From: Simon Davis
Sent: 12 June 2018 12:30
To: Planning.Responses
Subject: FW: BN/22/18/PD

Comments from Barnham Parish Council.

Further to our email exchange about the above application Barnham Parish Council would like to submit some comments which they hope can be considered when the application is discussed. The comments are as follows;

Block Plan

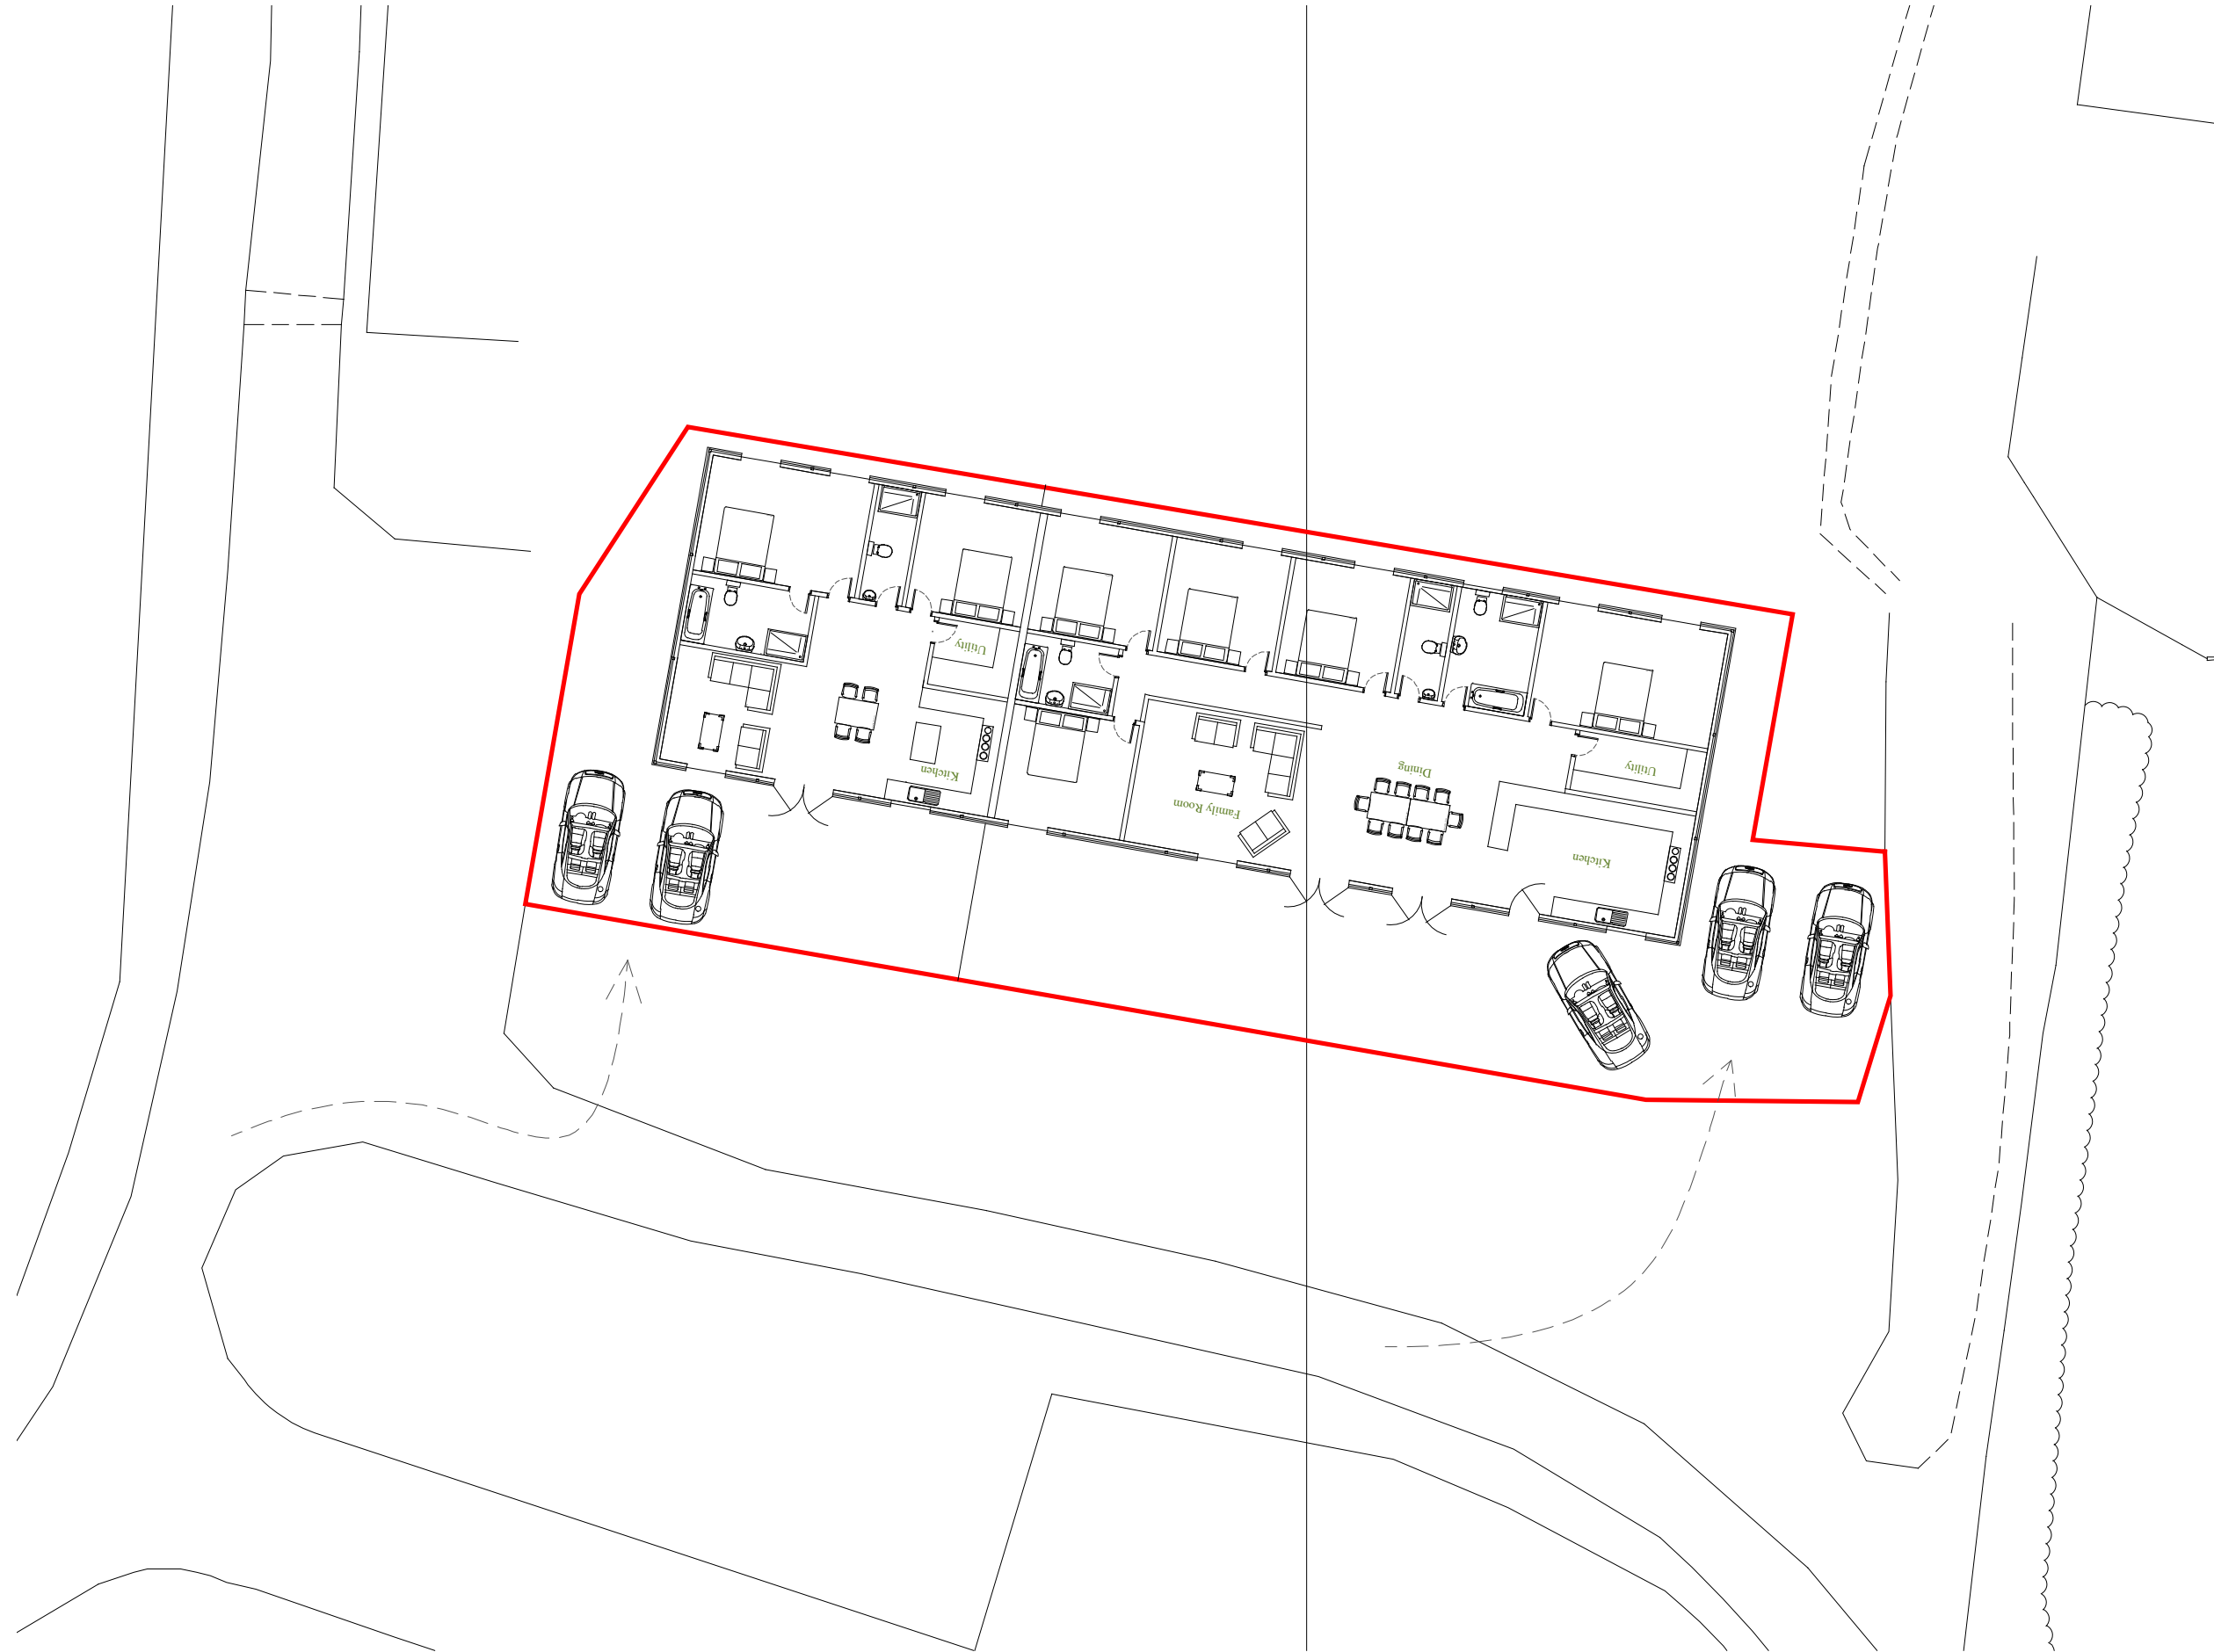
As the proposed dwellings are one of 5 bedrooms and the other 2 bedrooms is the amount of car parking space sufficient as only space for 5 cars. There does not appear to be any garden space for either dwelling.

Proposed

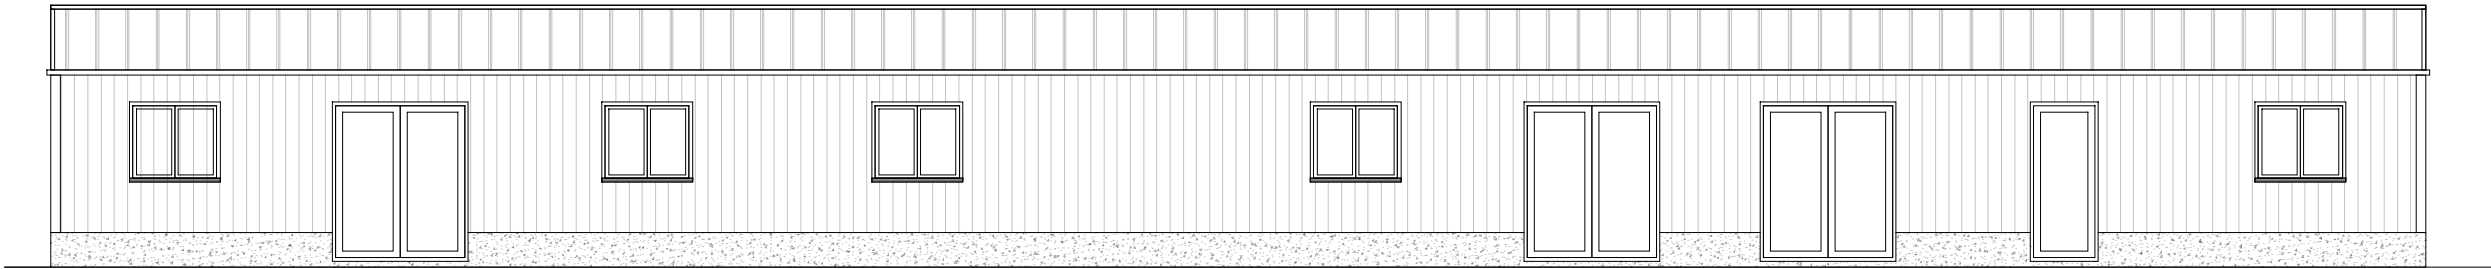
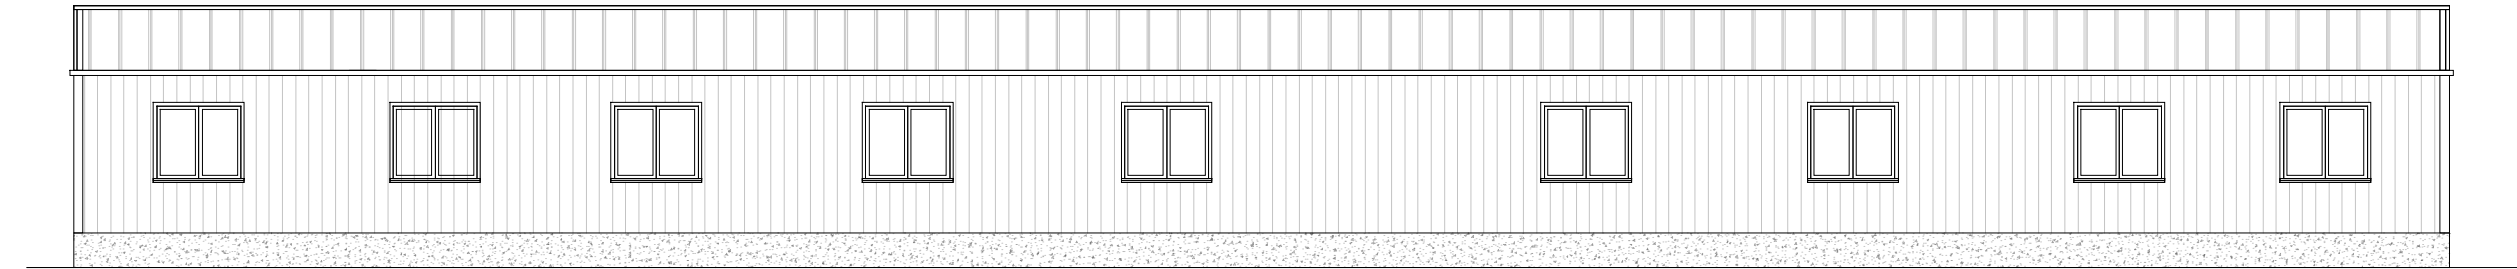
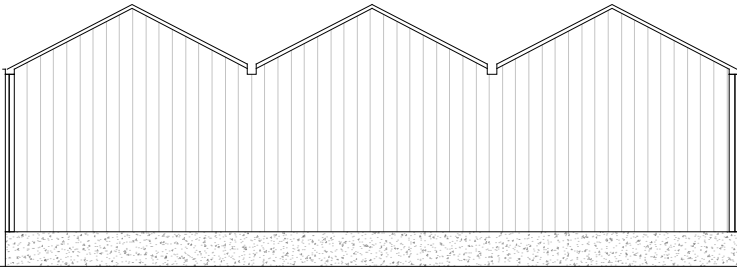
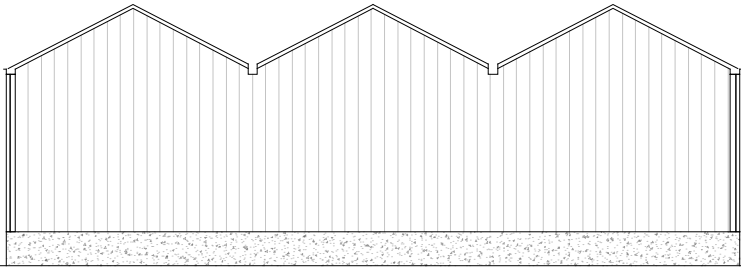
Finally the appearance is unattractive and not in character with the semi rural surroundings as the building will be wooden clad it resembles army barracks.

Sections

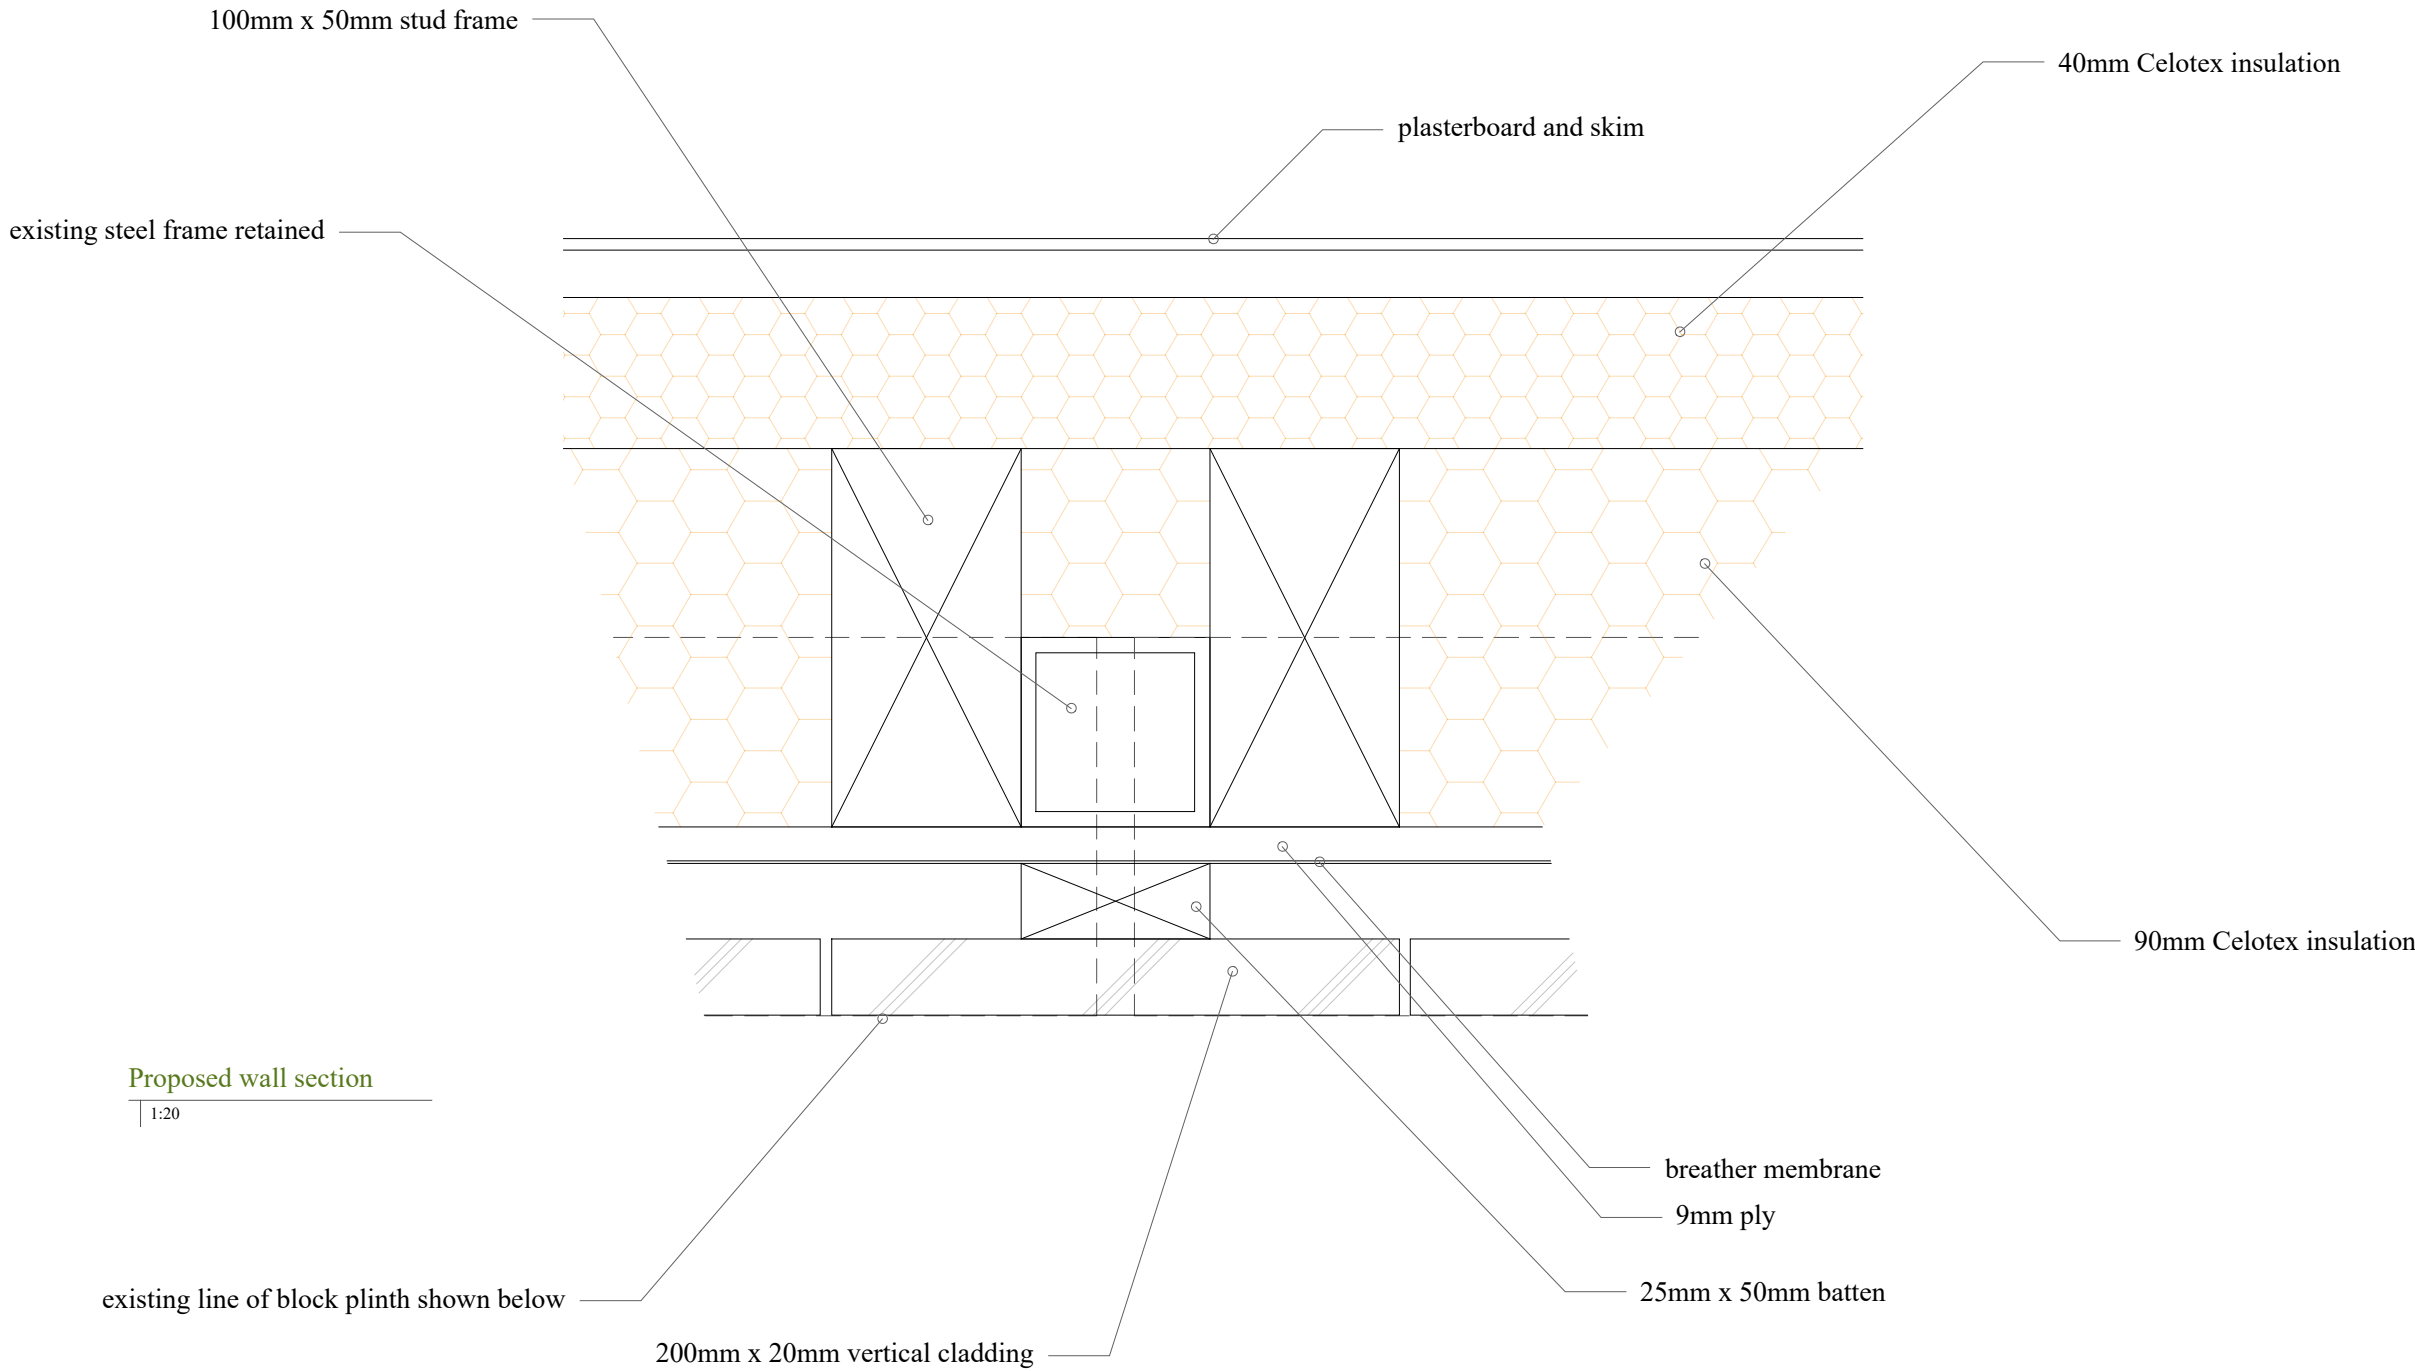
As they intend to infill between the existing greenhouse frames the Council is concerned about the safety of any building that would be erected and would wish to be assured that the derelict greenhouse frames are in good enough condition to be used in a residential building and the footings sufficient, secondly fire regulations are a concern the insulation suggested is celotex which we understand is flammable and the building will be finished in wooden cladding.
